Date: 06/18/2024

Re: Truss Repair Verification
Location: Lot 53 Birchwood Grove (194 Robert Howe Dr. (Fuquay-Varina, NC))
JDS Project No.: RDU2406207
Date of Inspection: 06/17/2024

PROJECT: LOT 53 - BIRCHWOOD GROVE

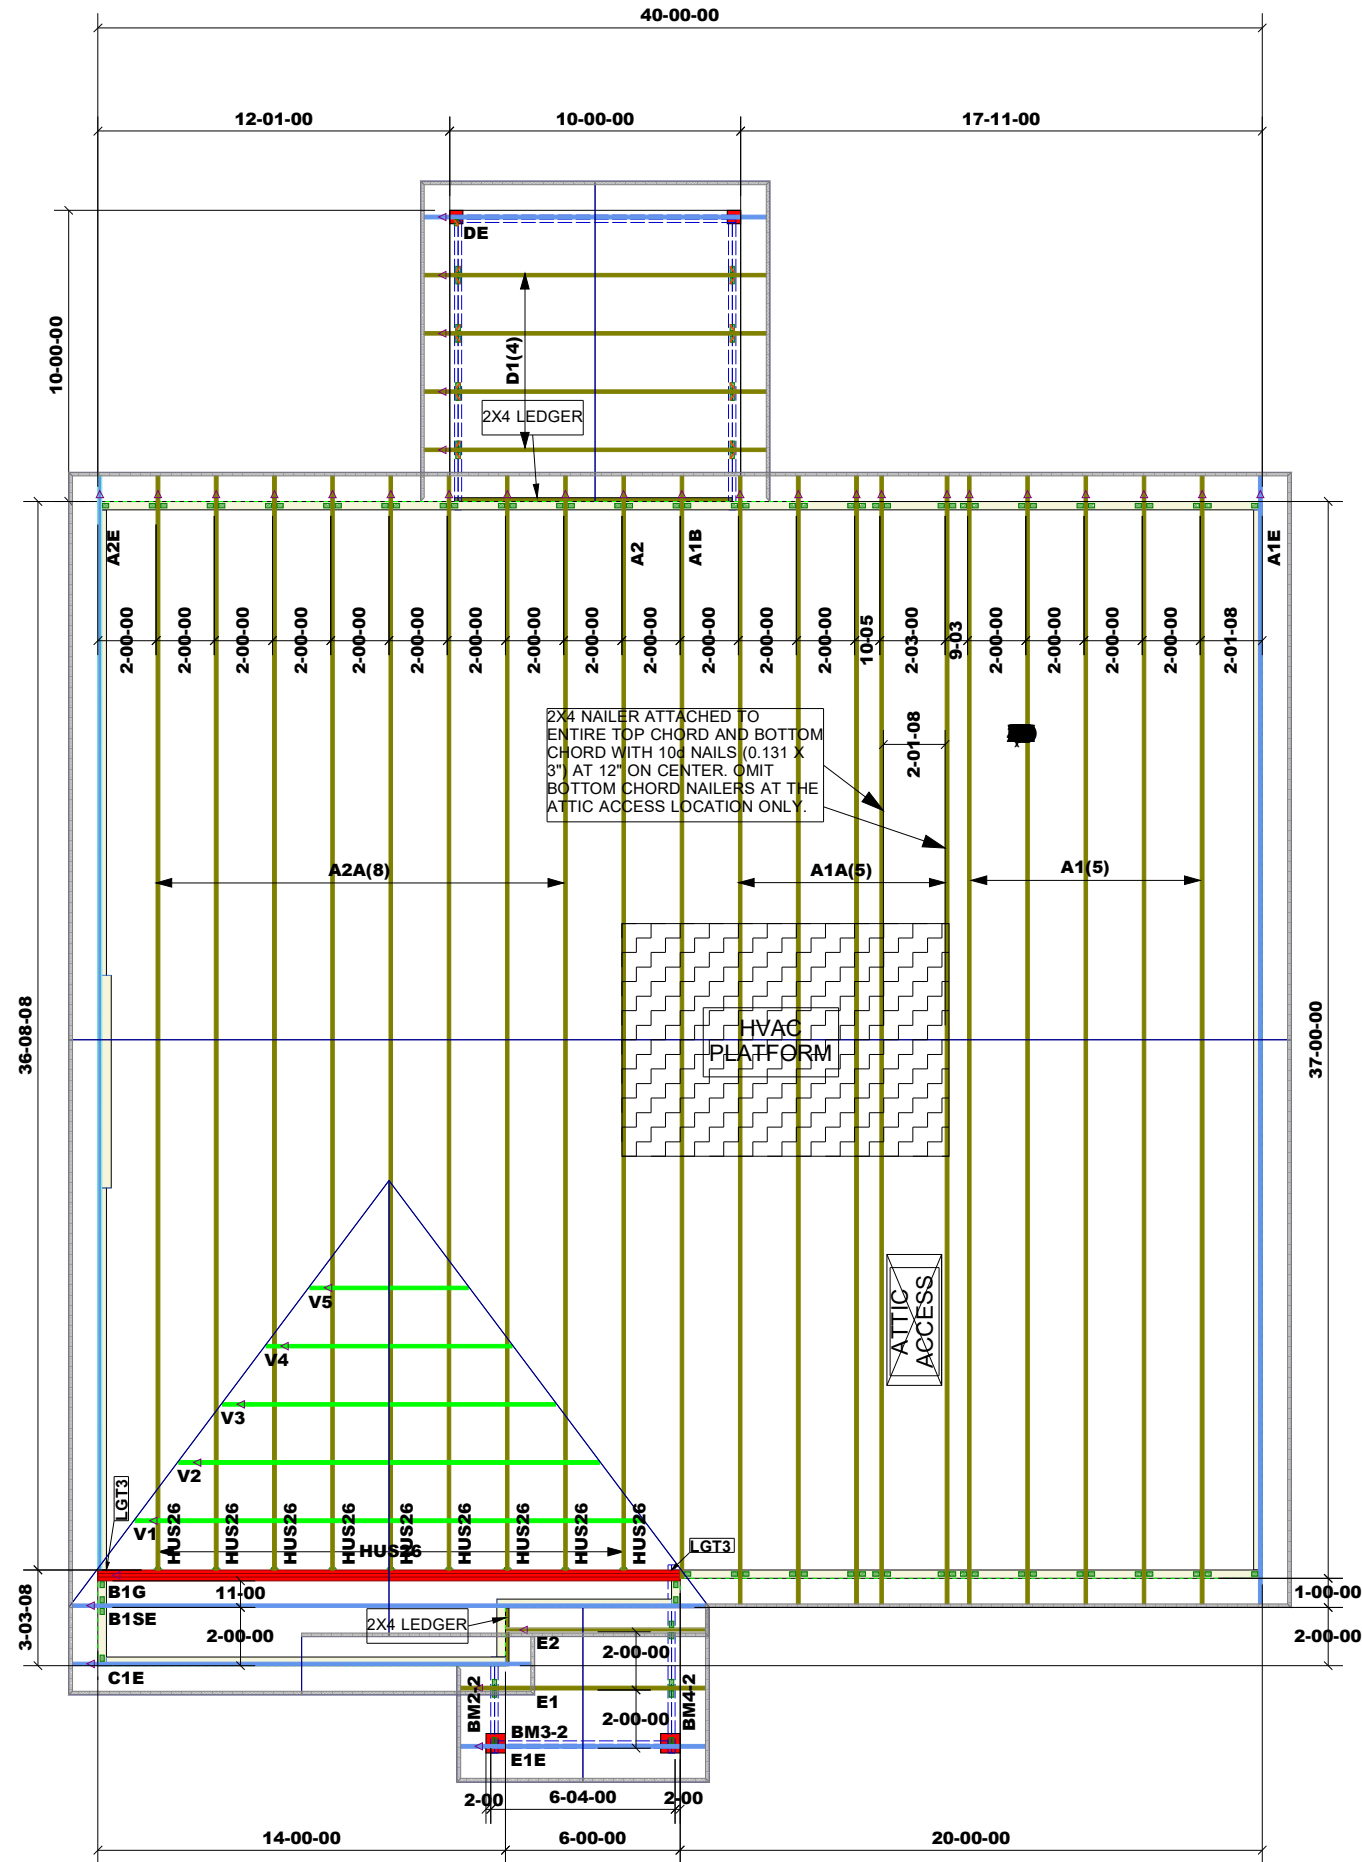
Verification has been requested of repairs recommended in JDS Consulting report RDU2405382 dated 05/23/2024 for a bearing issue at the B1G 3-ply girder at the front gable. The repair has only (1) scab applied to the front face of the right end of the girder truss. The recommendations call for (2) 6' 2x6 scabs with the first scab to be nailed to the bottom chord of the girder truss. Then, an additional scab was to be attached to the 1st scab that had been nailed to the girder truss with structural screws.

Based on our onsite observations and review, nail the existing scab and then screw the missing 6' 2x6 scab to the existing scab and girder truss as described in the previous letter.
